From: Jason [REDACTED]
Sent: 19 September 2013 14:51
To: Anita Gardner
Subject: RE: Planning Consultation on: LU/241/13/L
Attachments: Toddington House Partdrawing no P63 - for ref 19.09.13.pdf

APPLICATION NO: LU/241/13/L

Site Address: Toddington House Toddington Lane Littlehampton BN17 6JX

Description of Works: Application for Listed Building Consent for the demolition of single storey pantry to north elevation and erection of kitchen extension.

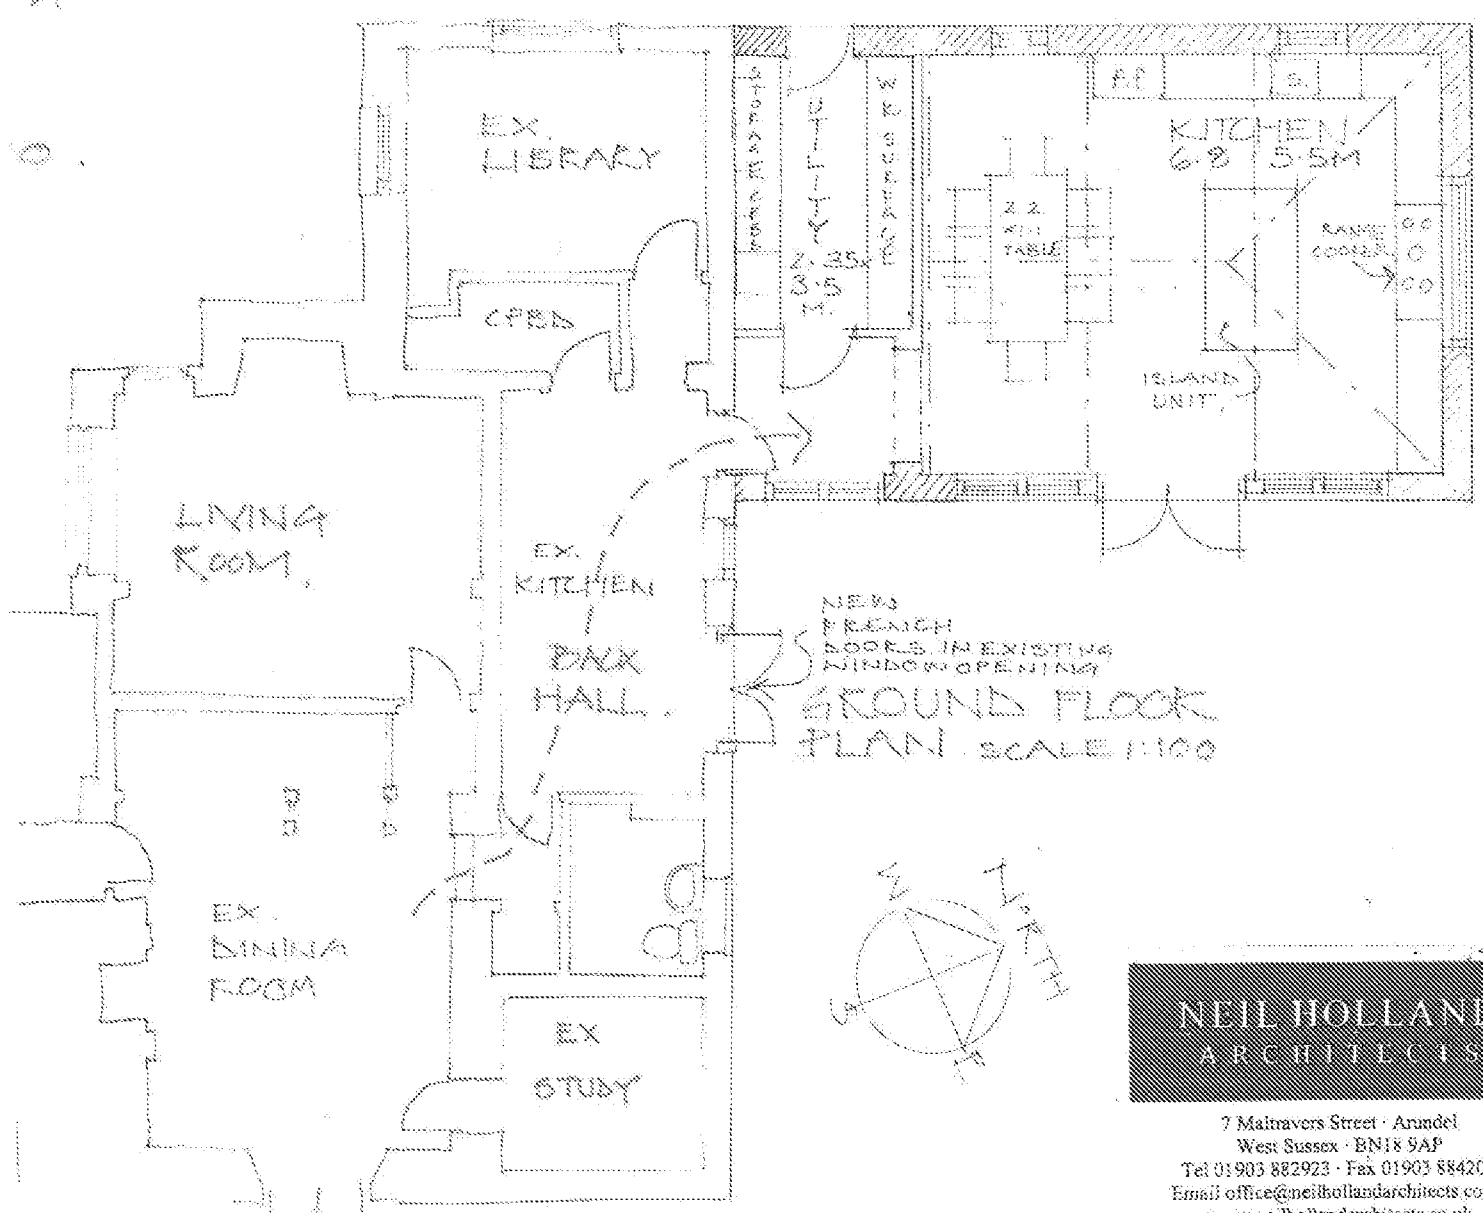
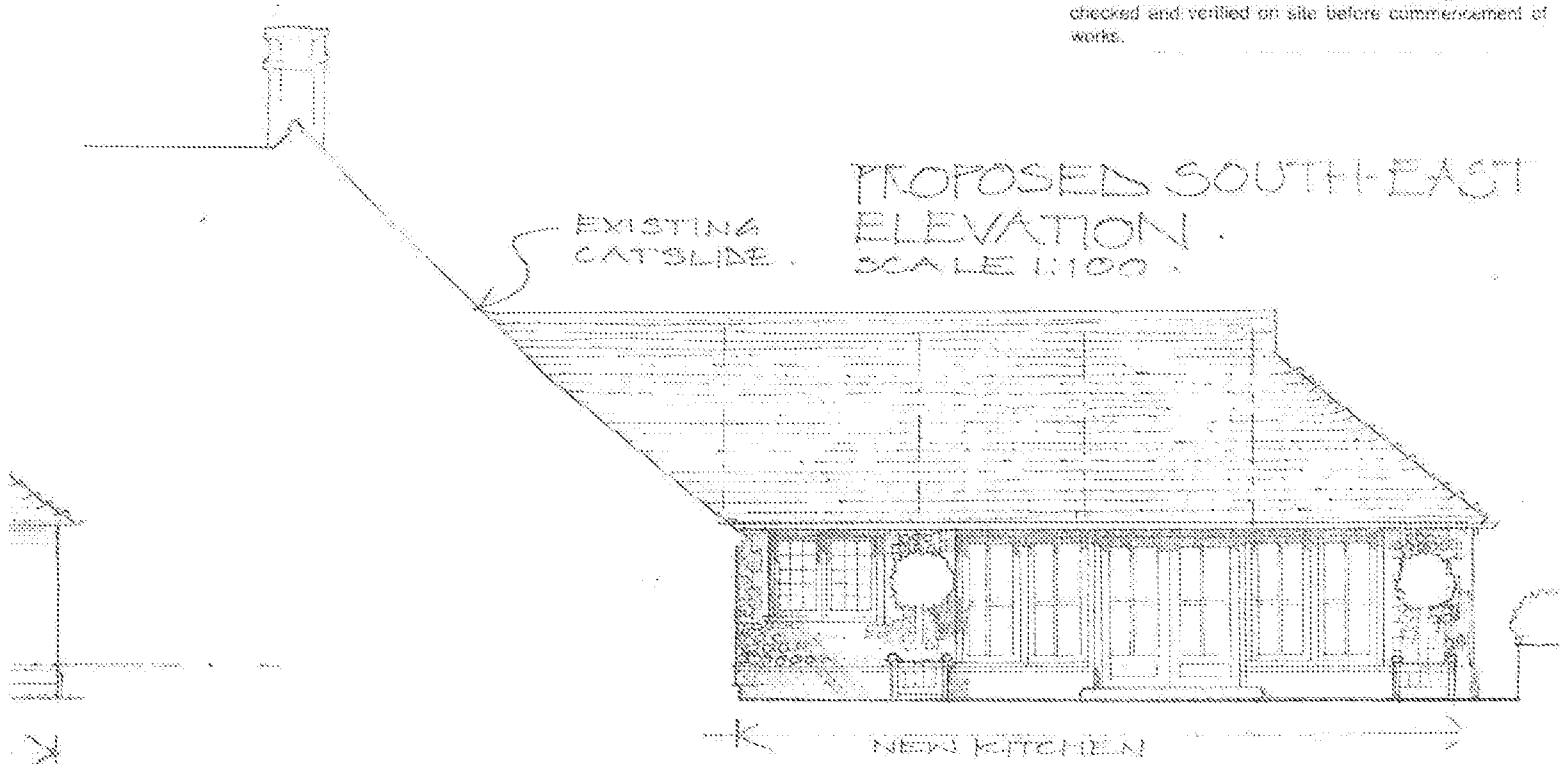
Dear Jason,
I attach Ian Wightman's comments for your information.
Accordingly, without prejudice, I would welcome receipt of amended plans reducing the length of the extension by approx. 2.5 metres. It would also be useful if the extract of the proposed ground floor plan could indicate the proposed use of the ex. dining room, kitchen and library.
Regards

I have attached a plan extract with the room names on for ease of reference.

The need for a proper utility room is largely borne out of the fact that the client is focusing on existing, much used large bedroom and kitchen equipment room store. The space for this can again be hidden away in its own space if housed in the proposed utility room.

During the design process we did look into putting the new utility room in the existing house -- the library and existing kitchen, but these two spaces are too good and important to the existing house design completely to become the utility for the following reasons...

The library has rather wonderful paneled walls with bespoke bookcases and complex ceiling structure. It is a very important element of the home and this room is a wonderful feature of the house. This is highly valued and will continue to be used as the library and music room. This makes the library an unsuitable option.

The existing kitchen space is to become the back hall and is the only thoroughfare through the main house to the new kitchen extension. Making this space into a Utility Room would be an unfeasible and impractically designed feature and would compromise the current, composite design features of the house and therefore would be unacceptable; the client understandably did not wish to risk a new utility unit.

Rooms such as the second bedroom are already being used as other rooms for ironing etc and combined with the above reasons, we believed this substantiated the need to position the new utility in the new extension out of the existing house.
